Listed Building Consent for Alterations, Extension or Demolition of a Listed Building

Development: Listed building consent for the replacement of double glazed aluminum / timber windows and doors with double glazed painted timber casement, sprung sash windows and matching French doors.

Location: Little Welbourne Church Lane Pagham PO21 4NX

GROUND FLOOR

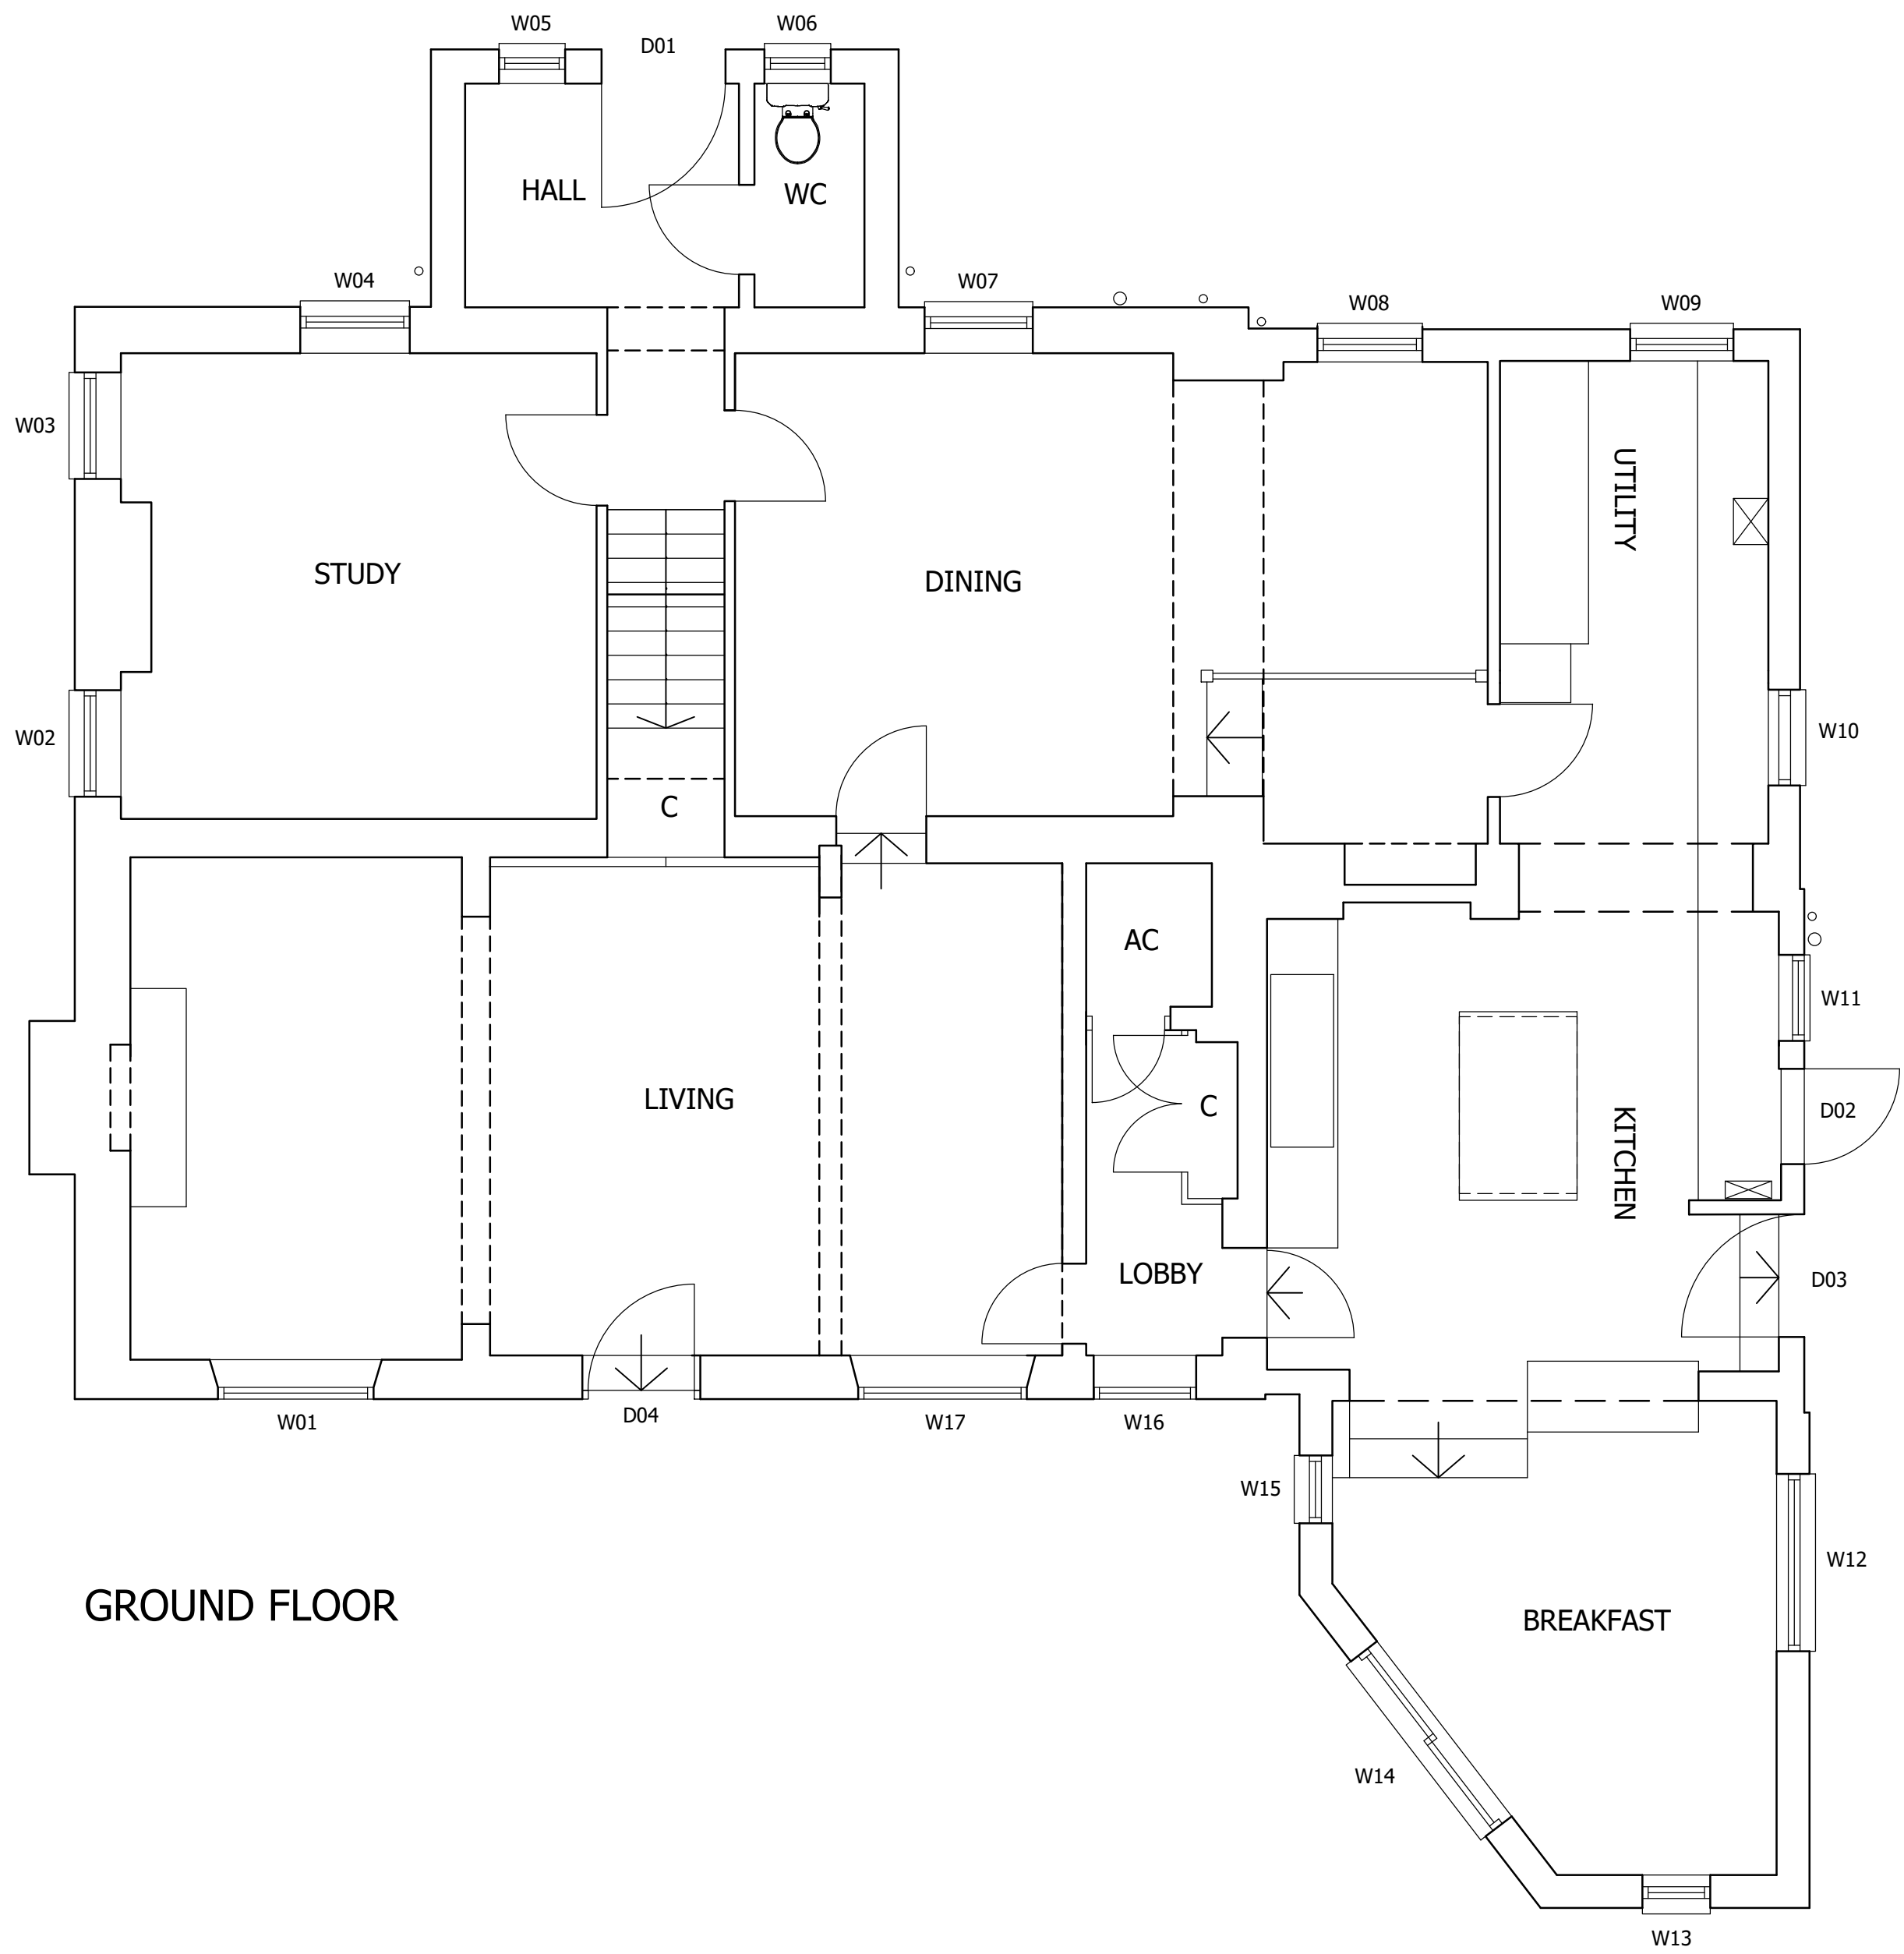
The proposed W10 north elevation door is drawn as a window on the proposed ground floor plan and isn't shown in the window/door schedule

EAST ELEVATION

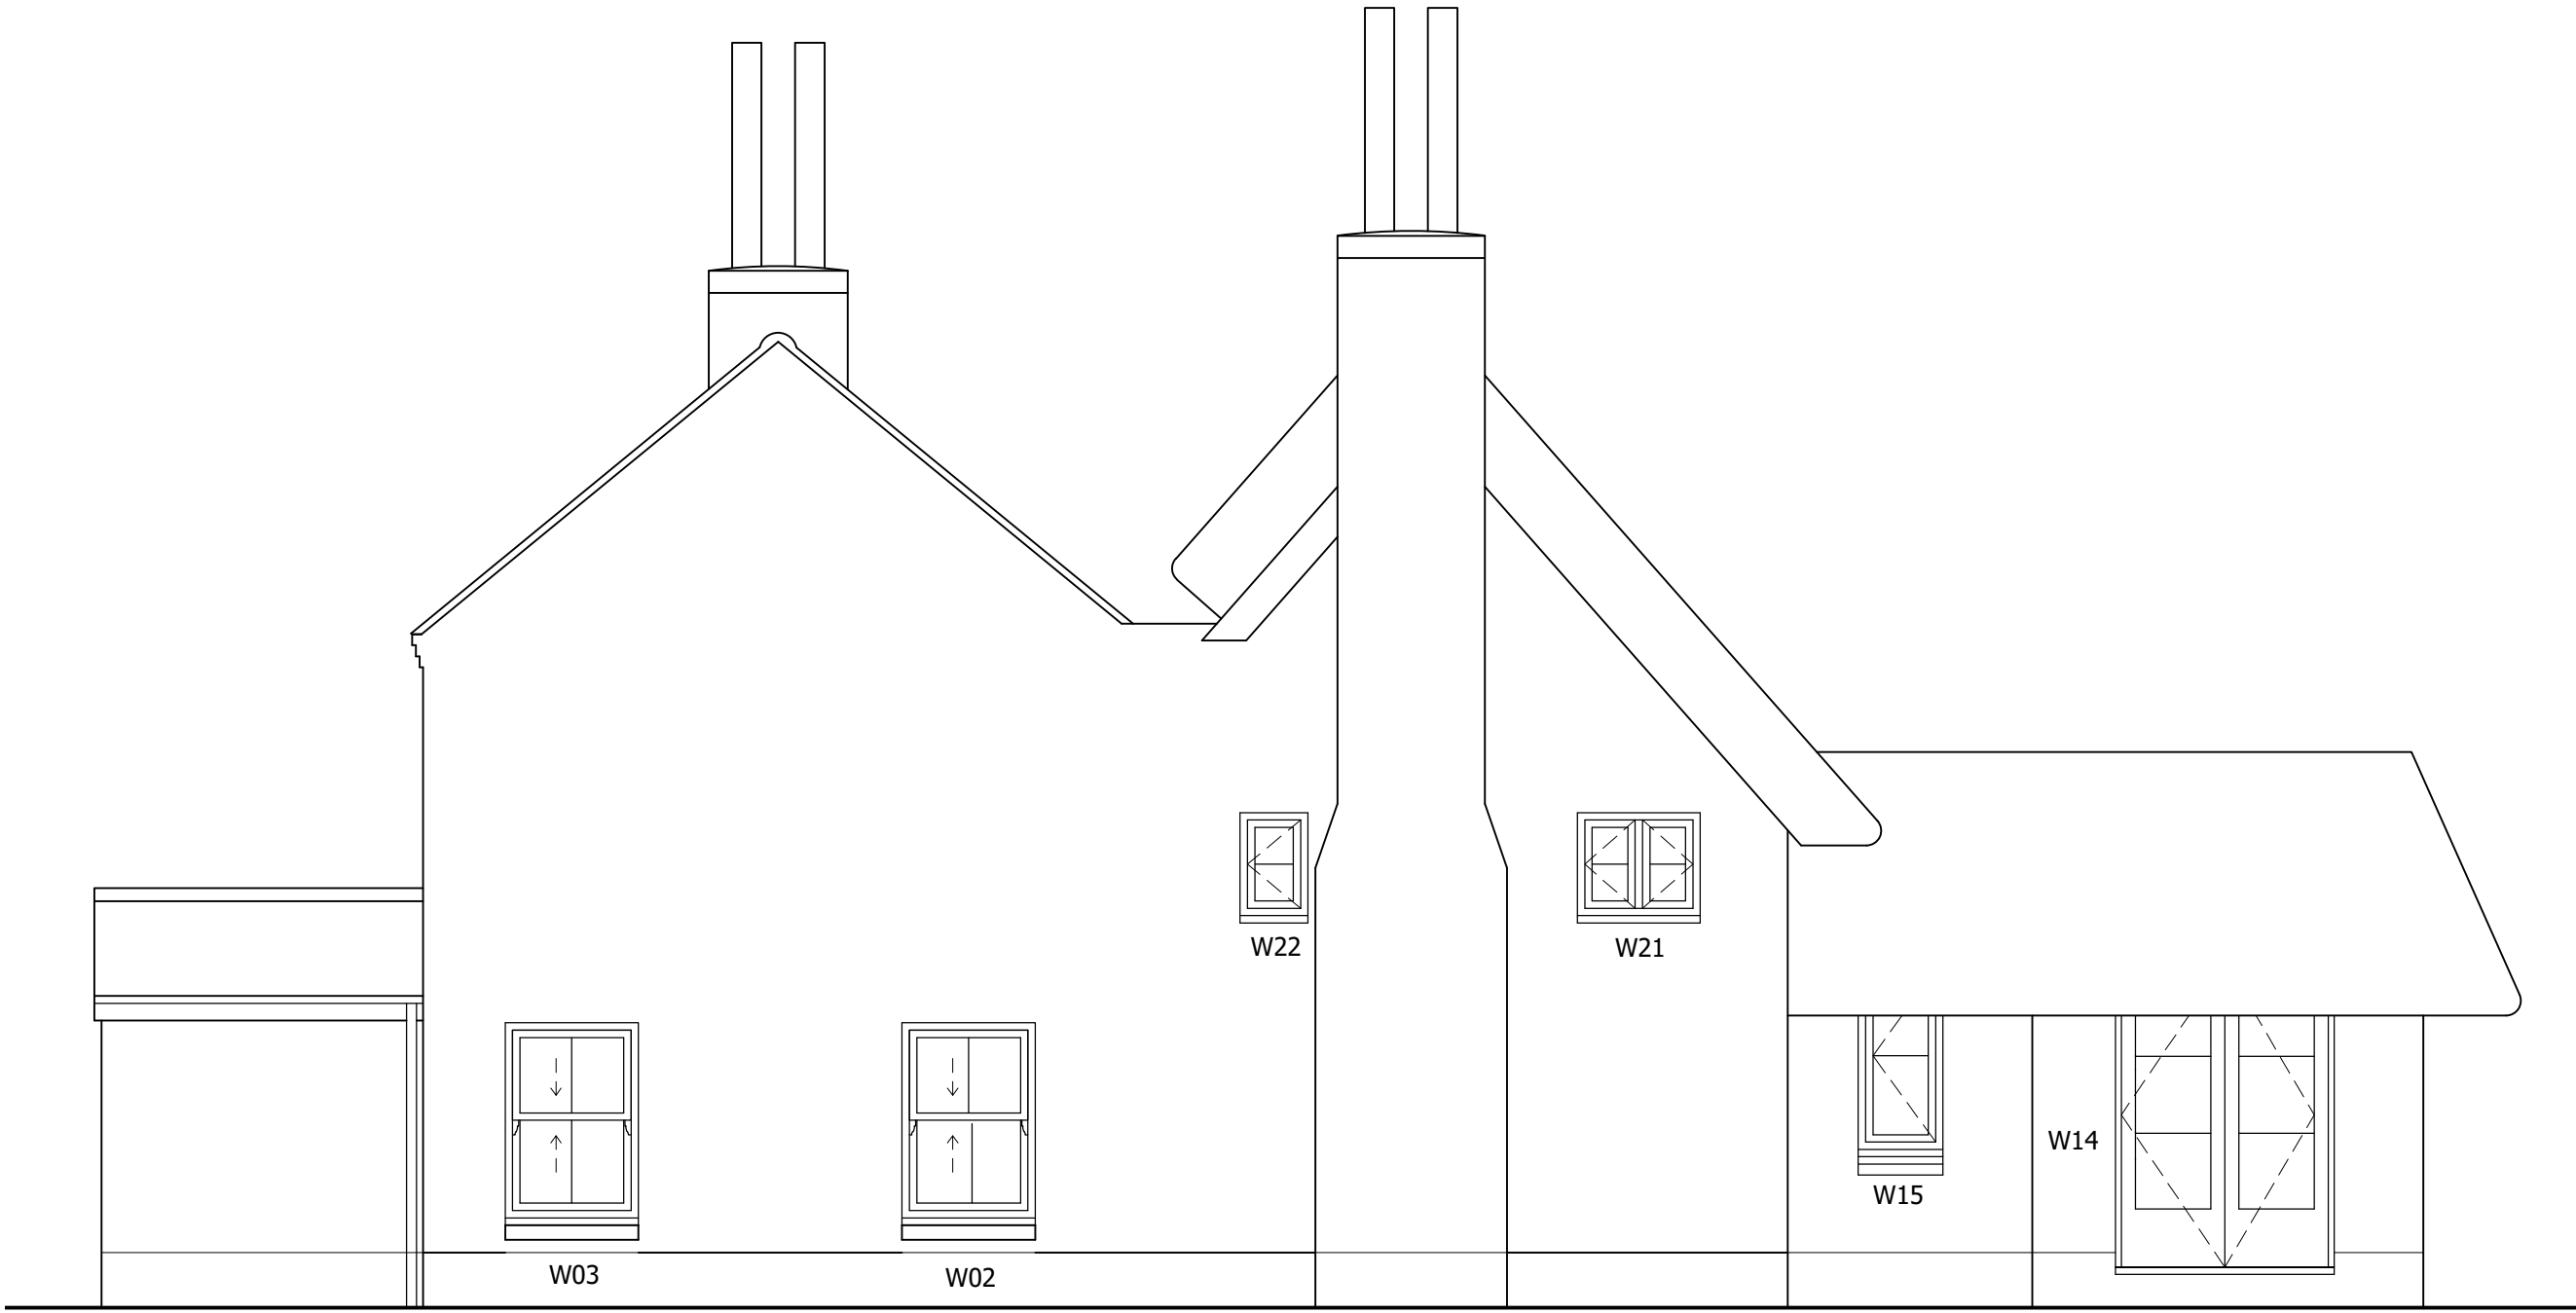
The existing and proposed east elevation plans have an inconsistency with the first floor balcony.

Part of the roofing on the proposed north elevation plan is inconsistent with the existing north elevation plan. Please clarify or amend. If changes to the roof are within the proposal then a roof plan will be required and works should be included in the application description.
